COUNTY COUNCIL'S RESPONSE TO CONSULTATION ON THE FOLLOWING DEVELOPMENT PROPOSAL

Application No: 17/02394/OUT

Proposal: Outline planning permission for up to 60 dwellings with associated landscaping, open space and vehicular access off Berry Hill Road.

Location: East Of Last House Adjoining And North Of Berry Hill Road, Adderbury

Figure 5.1 – Location of Accidents

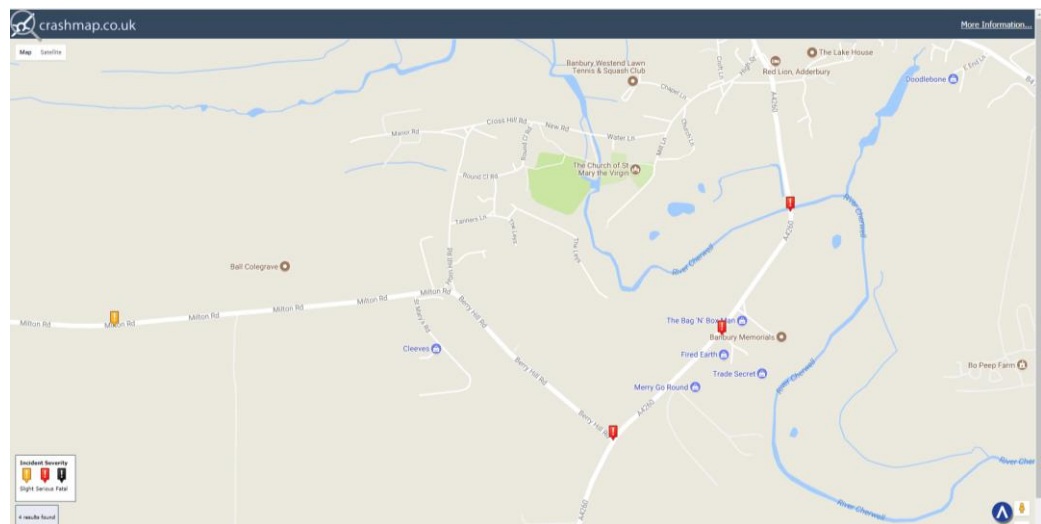
Section 5 of the TS presents an accident analysis. The data used has been taken from the Crashmap website which does not represent the most up to date personal injury accident (PIA) data available. The latest PIA data can be obtained from Oxfordshire County Council. The time period over which PIA data has been examined is unclear as paragraph 5.1.1 states "*the five year period 2014 to 2016*". No details of the PIAs presented in this section are presented. For these reasons the accident analysis is deficient. **Reason for objection.**

DRAWING NUMBER:	1899-F01	REVISION:	A
-----------------	-----------------	-----------	----------

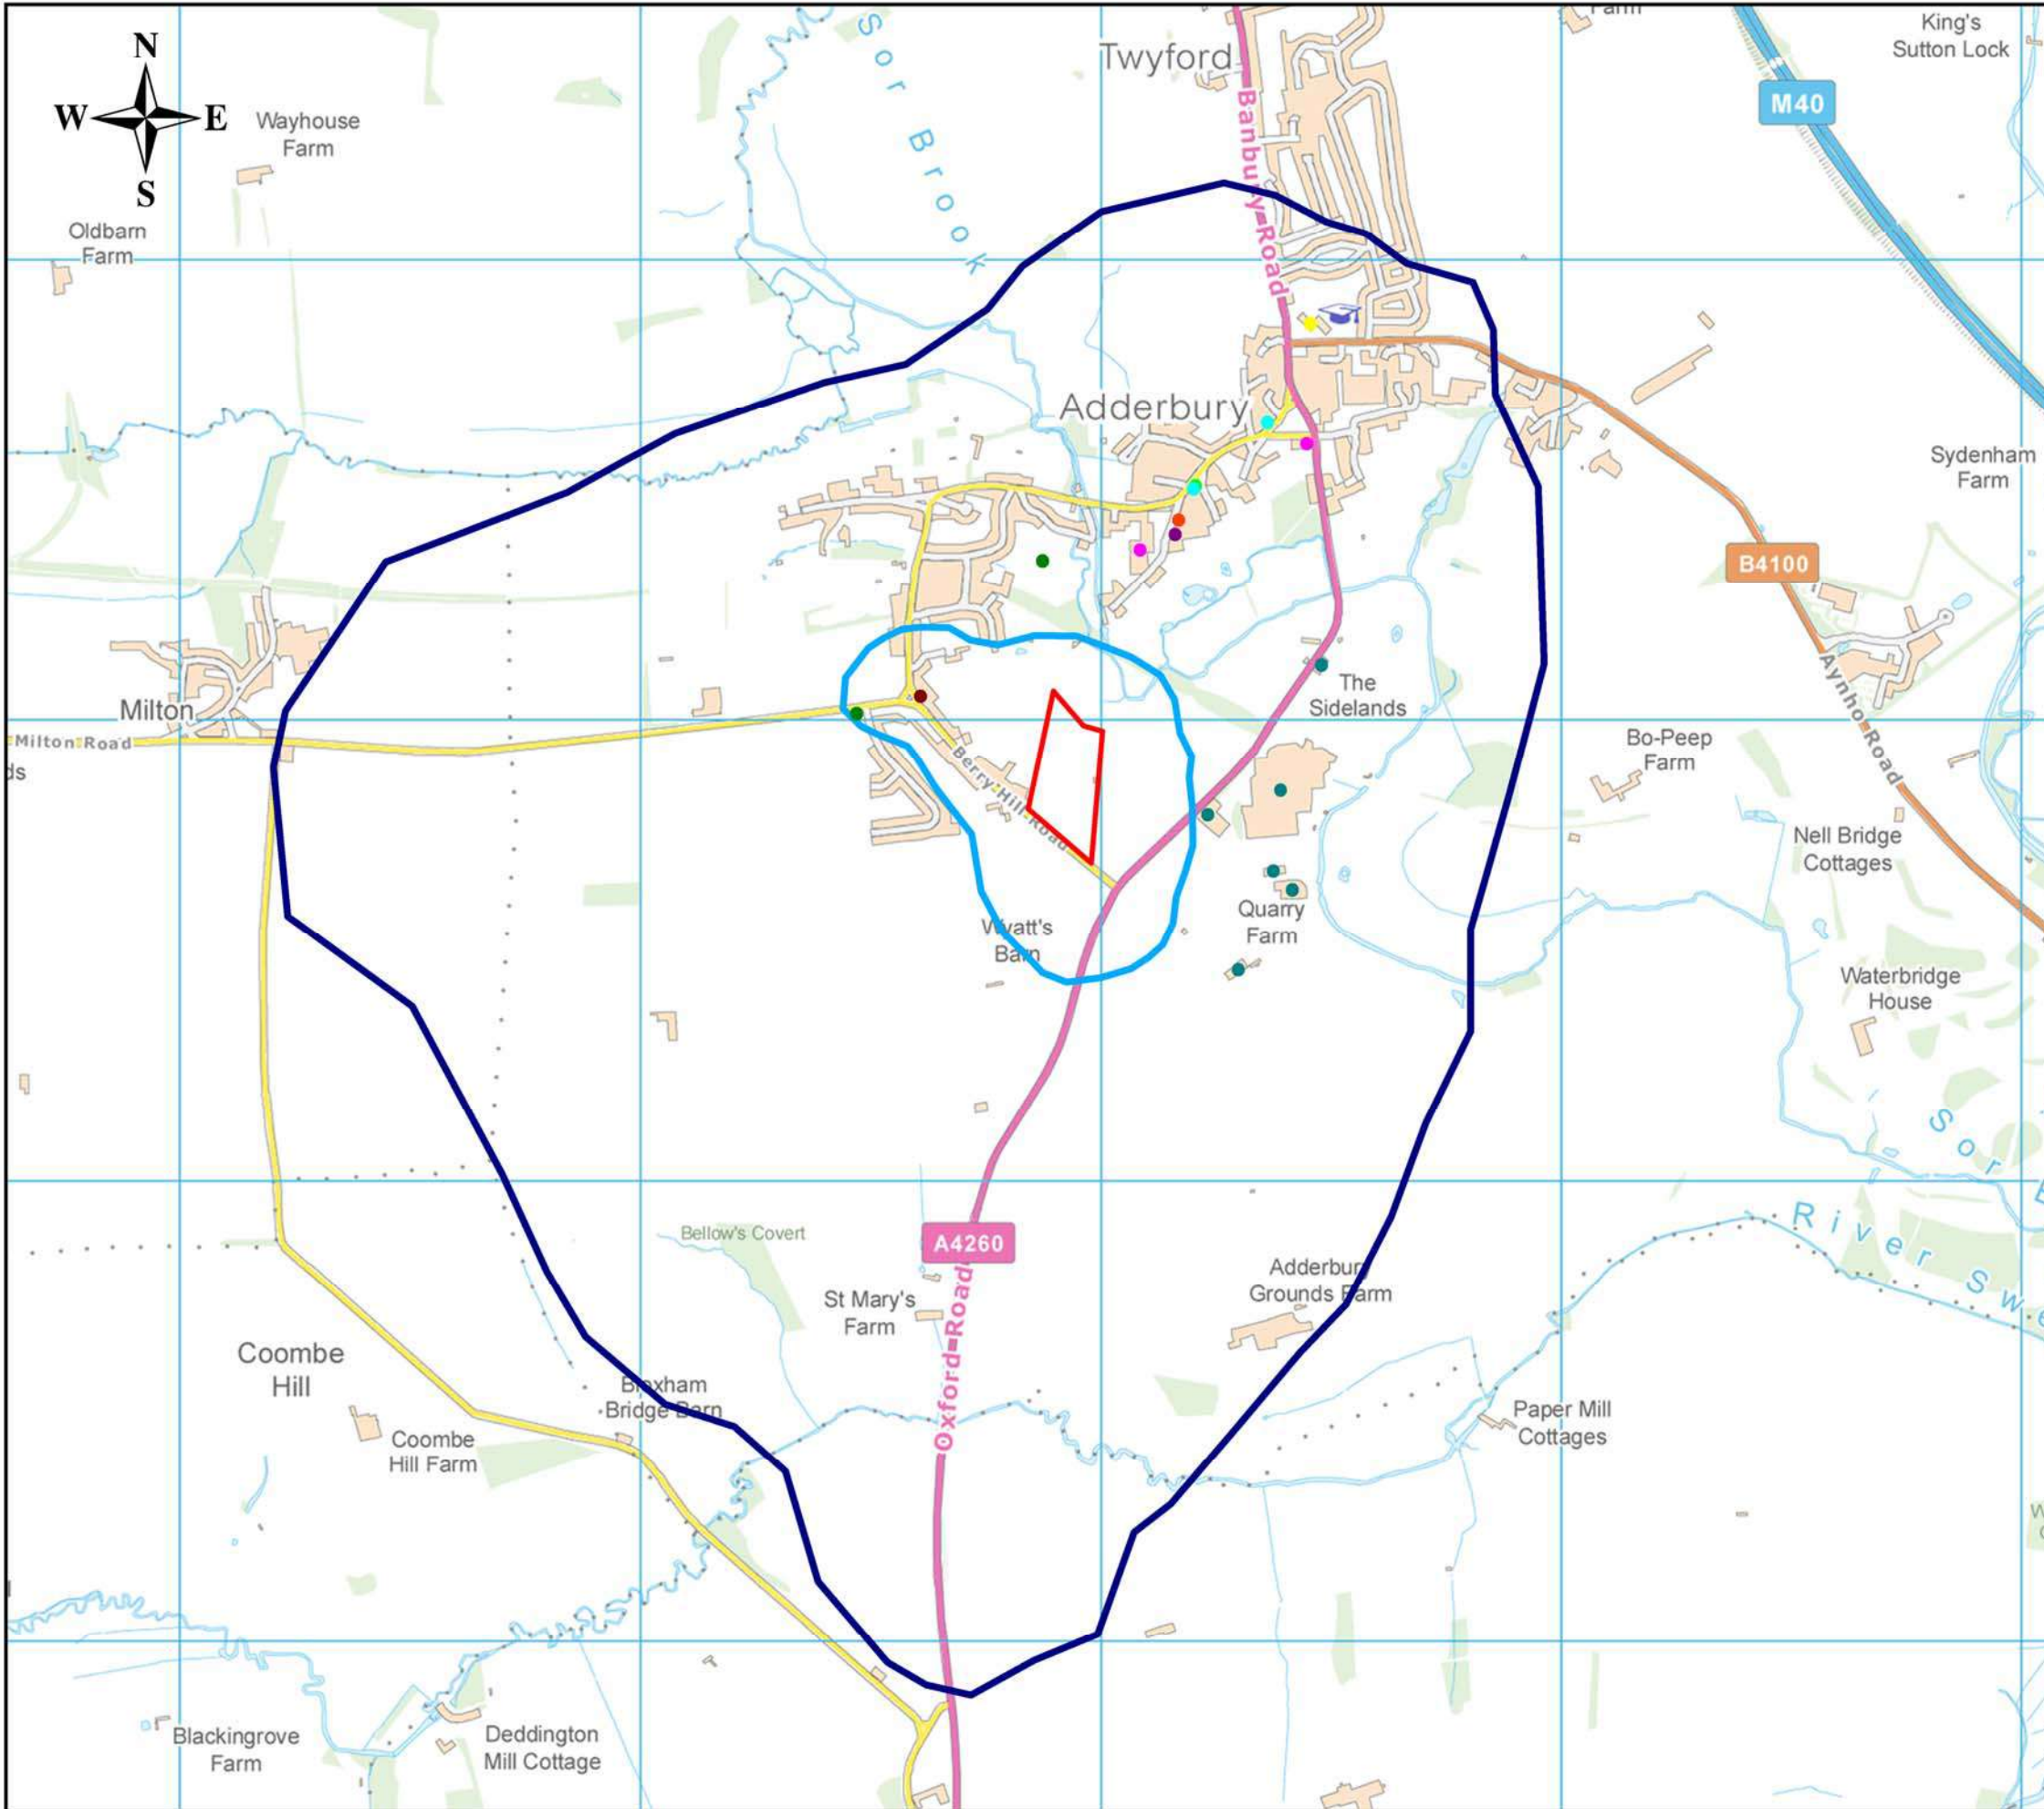
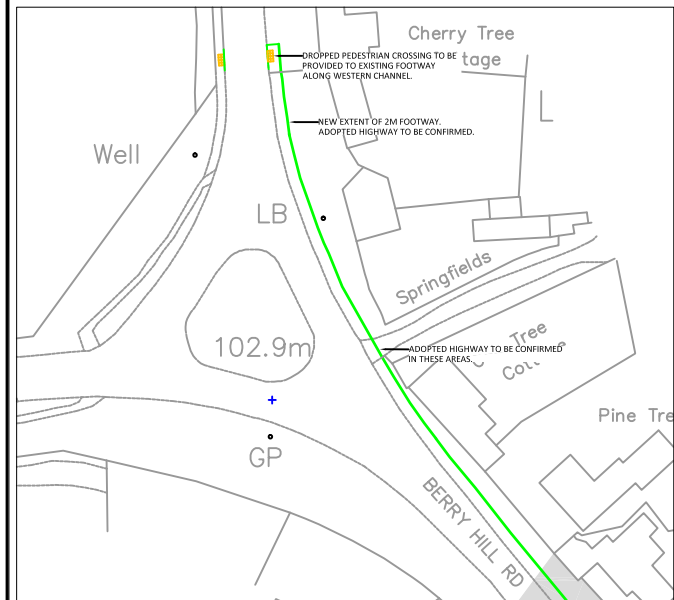
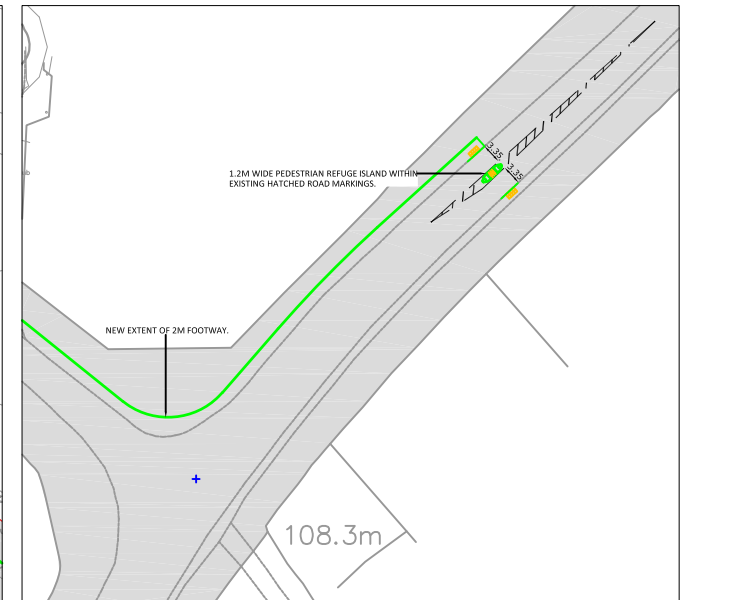
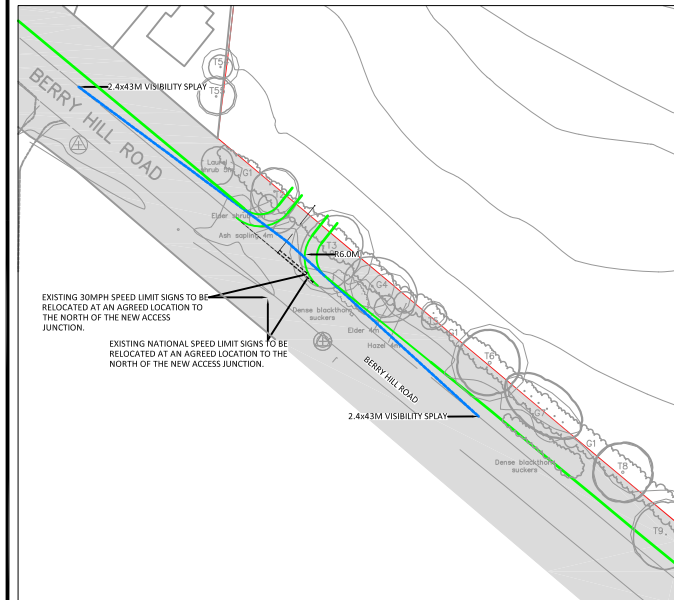
Paragraph 2.5.4 introduces the intention to provide a new footway on Berry Hill Road. This is indicated on drawing No.1899-F01. The northern sections of this footway are annotated "adopted highway to be confirmed". This suggests that the feasibility of a footway linking the development site with the existing footway on Horn Hill Road is not established. This footway is regarded as an essential provision for a development site with relatively poor sustainability credentials and its deliverability must be established. **Reason for objection.**
